# BOLTON BY BOWLAND, GISBURN FOREST & SAWLEY PARISH COUNCIL

22 July 2019

**Applicant: John Foley Planning Application No: 3/2019/0588 Grid Ref: 377329 449543  
Proposal: Change of use of agricultural land to parking and landscaping. Two poly tunnels and stone service area. Location: Holden Clough Nursery Bolton by Bowland Road Bolton by Bowland BB7 4PF**

Holden Clough Nursery -
Proposed Overflow Car
Park & Growing Area
Scale: 1:500 @ A3

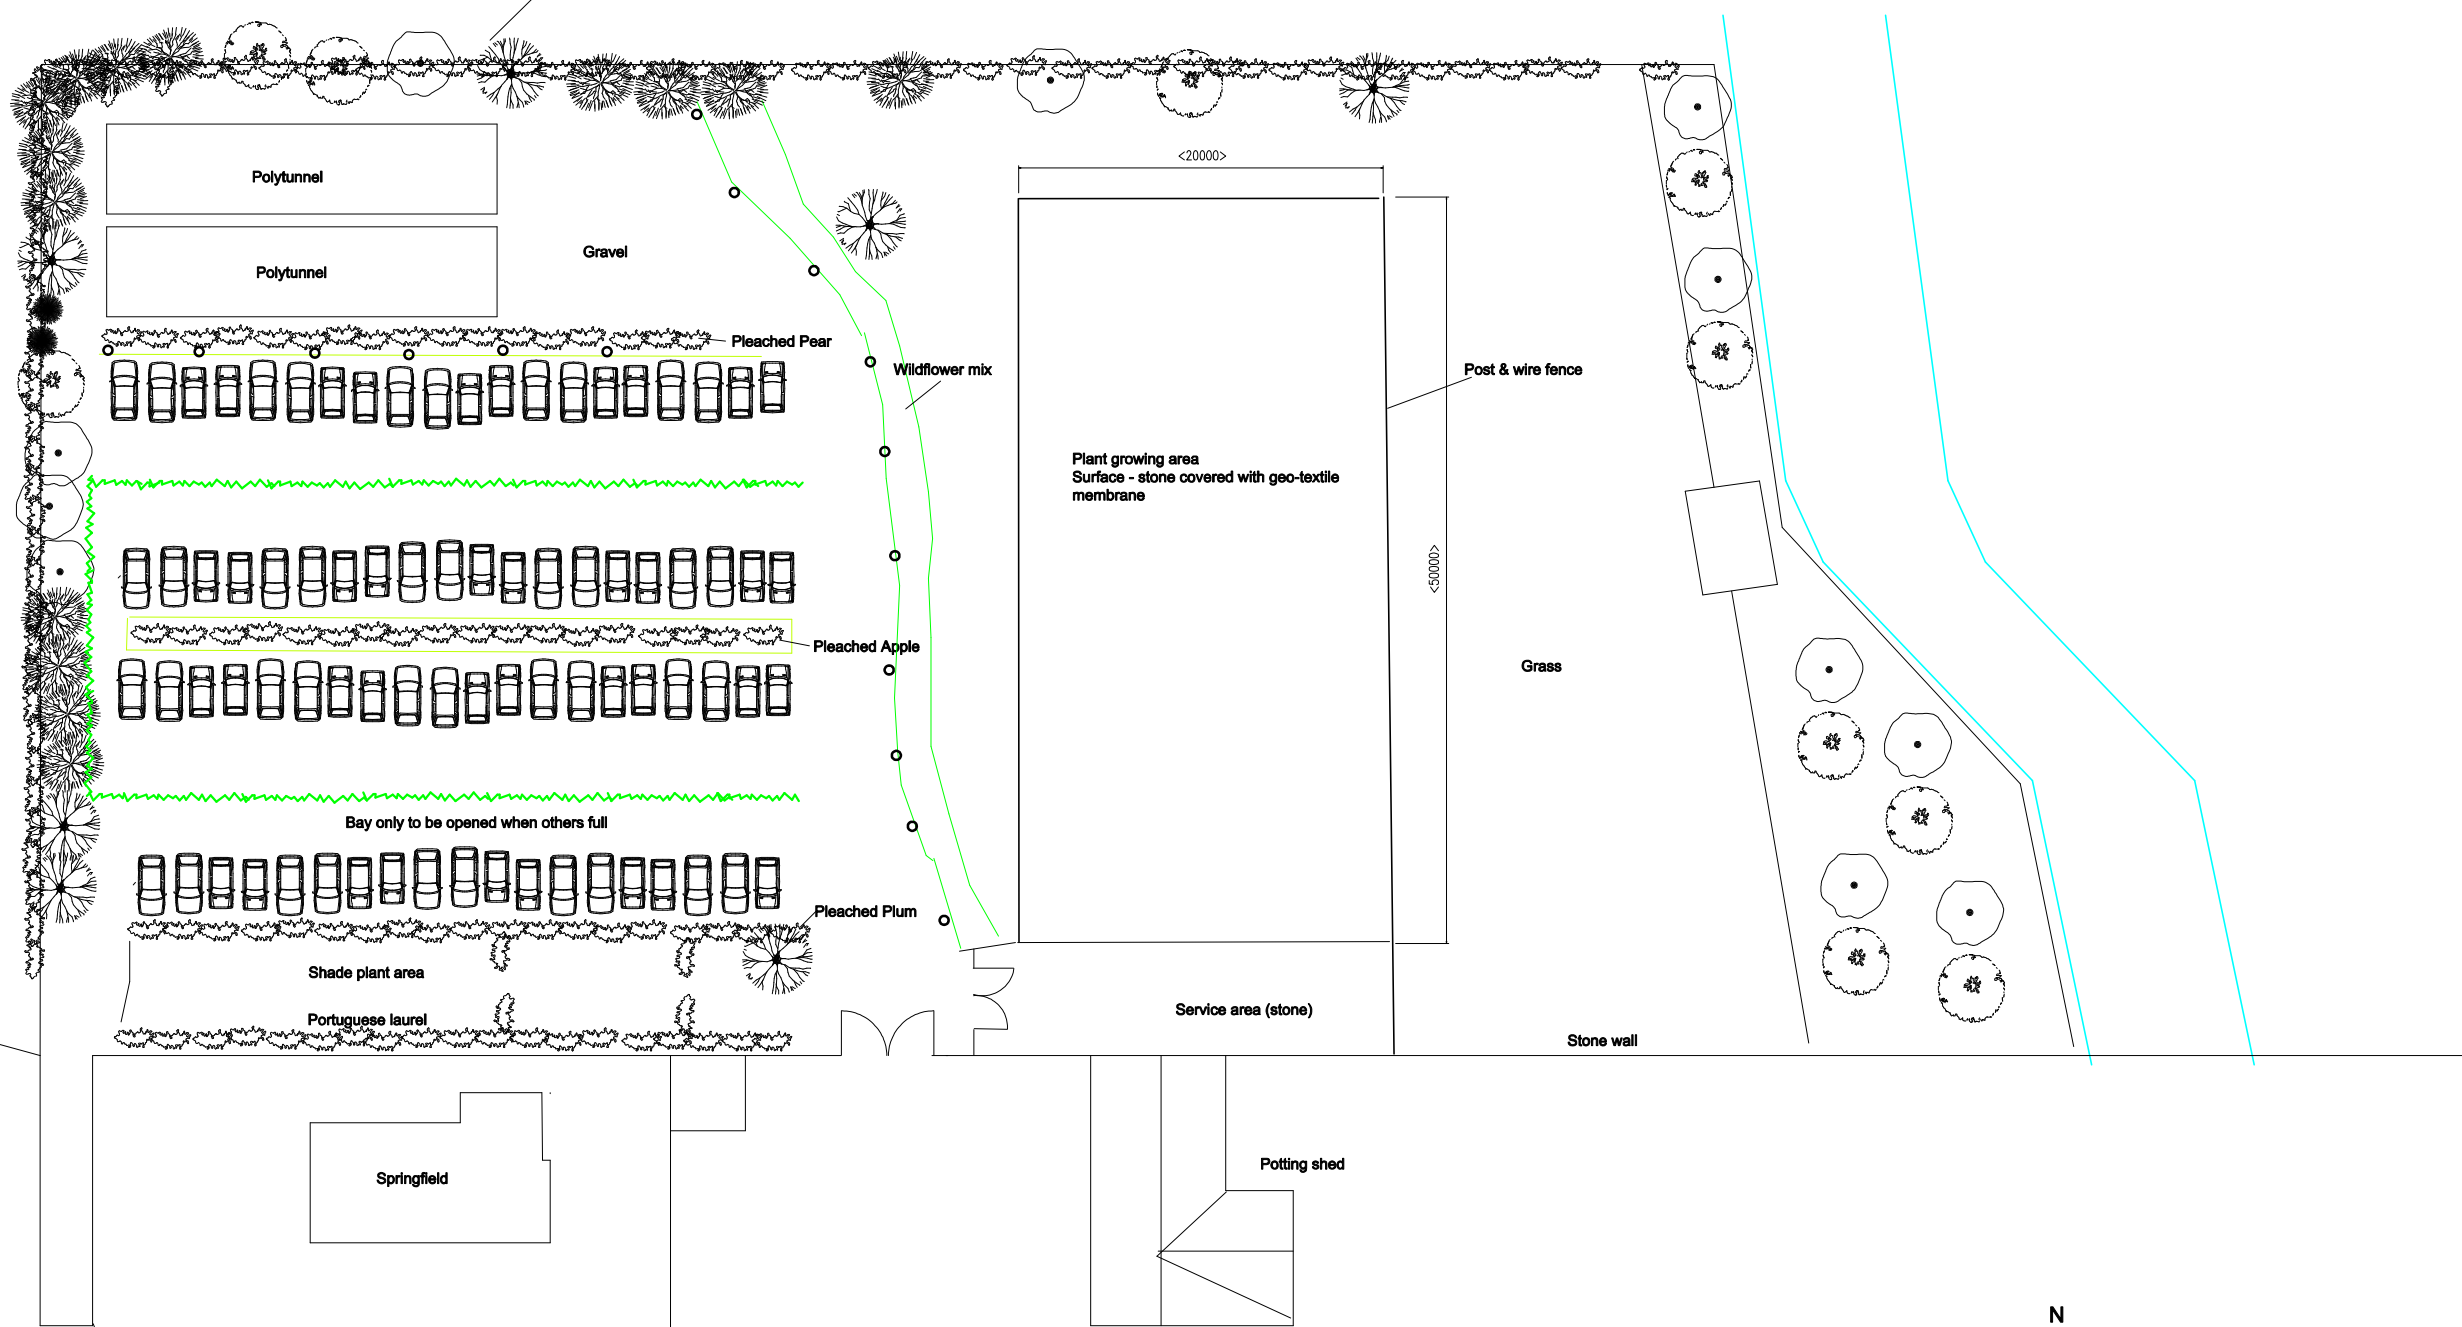
- It is widely acknowledged that cars have been parked on the narrow lane outside the Nursery for some time and all have considered that car parking within the site has been inadequate for the visitor numbers of this expanding business. 109 car parking spaces does seem excessive, however the actual layout and siting of the car parking spaces is causing concern to both residents and Parish Council. Mr. Foley explained his reasons for this plan, however there was no meeting of minds in terms of the concerns expressed of the detrimental effect this further development would have on the character of the local area, nor the effect of the proximity of siting the car park areas adjacent to residential properties. The proposal in its current format will have an adverse visual impact on the landscape & locality of the small rural hamlet of Holden and cause disturbance to the wider community.

- The layout of the proposed area will have a major impact on several residential properties, due to the proximity of the cars. It was considered that the layout in the application could be designed to mitigate the inevitable disturbance and detrimental visual impact this will cause.
